Ferring Parish Council

Re FG/138/21/PL

location site

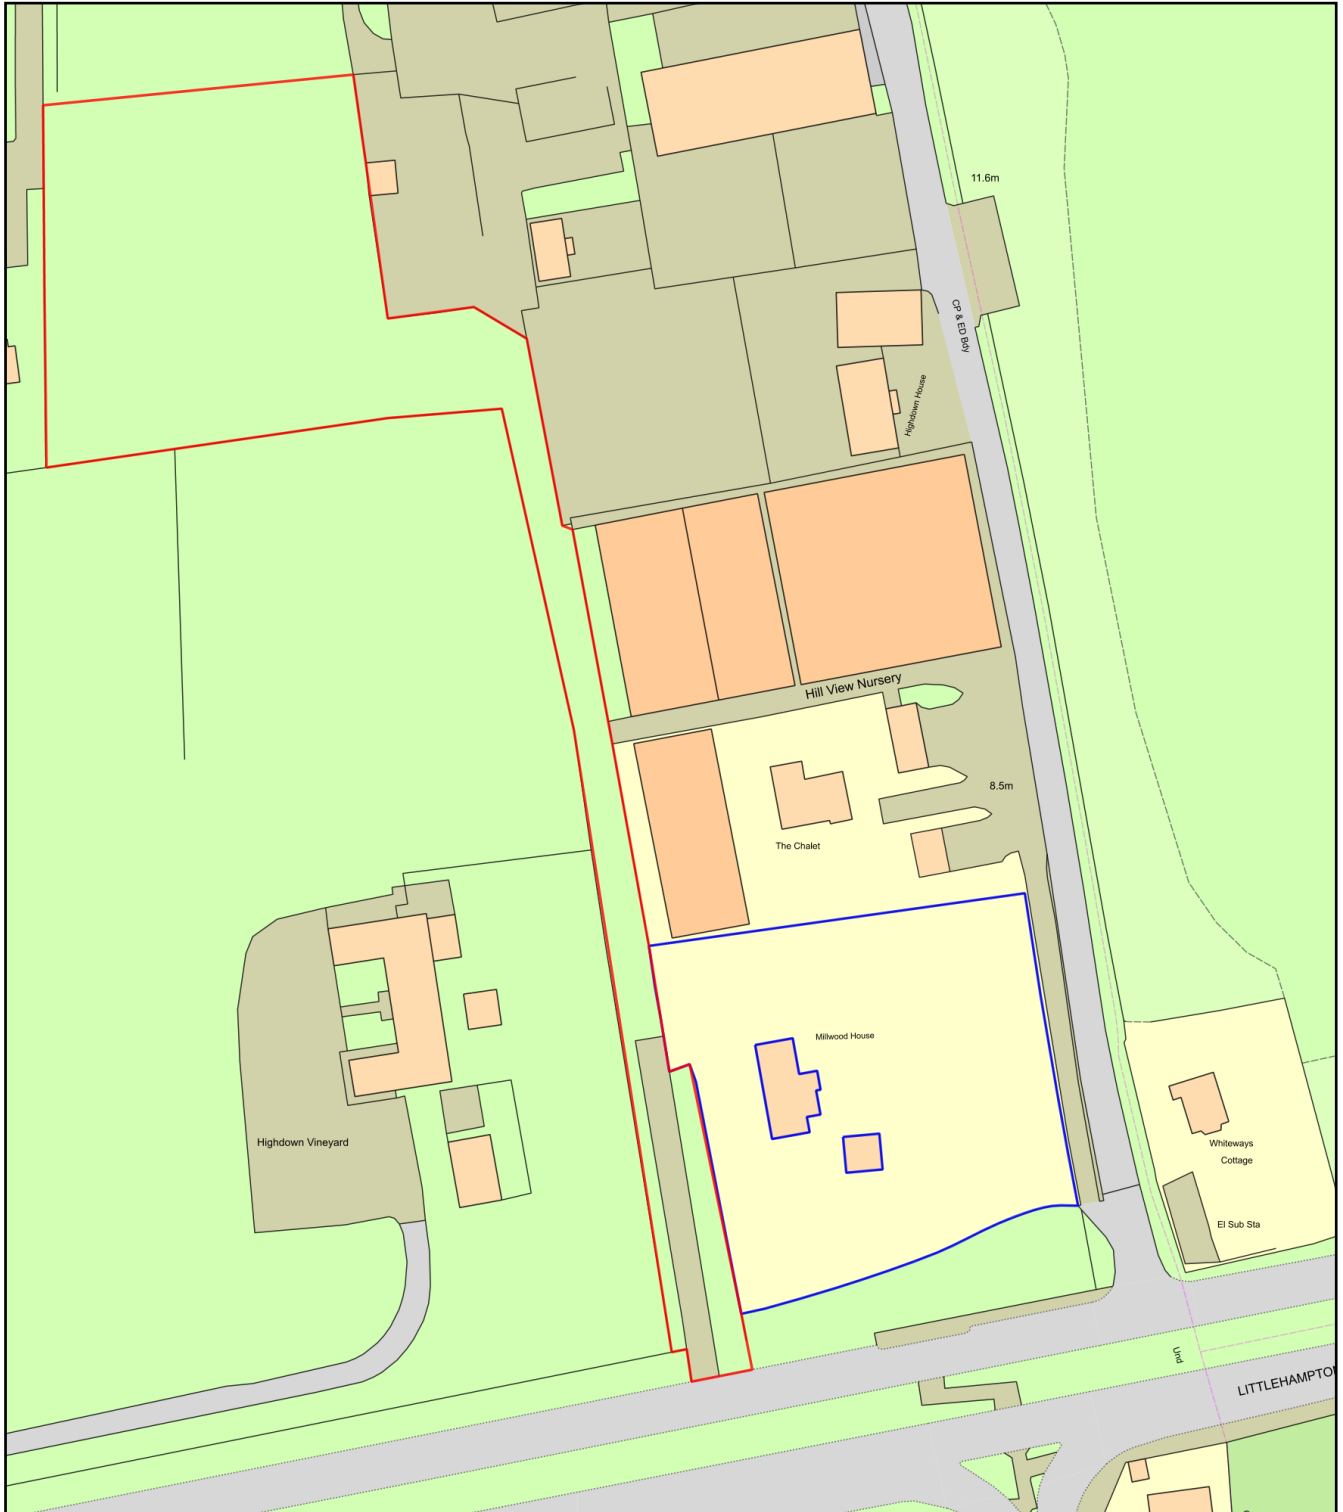
The proposed screening would be inadequate and reference to the established trees on the northern side or other planting are outside the red line boundary as indicated on the applicant's own site plan. The trees would therefore not be subject to any conditions that could be made on this application. The applicant considers and has confirmed on the application, that the trees shown as adjacent to but outside the site boundary do not influence the development and are not considered by the applicant to be important as part of the local landscape character. They are not currently protected by TPO's, could be removed at any time and are deciduous. This contradicts the claim made in item 5.2 of the applicant's design statement as providing the appropriate screening from Highdown Hill from which the site would be visible.
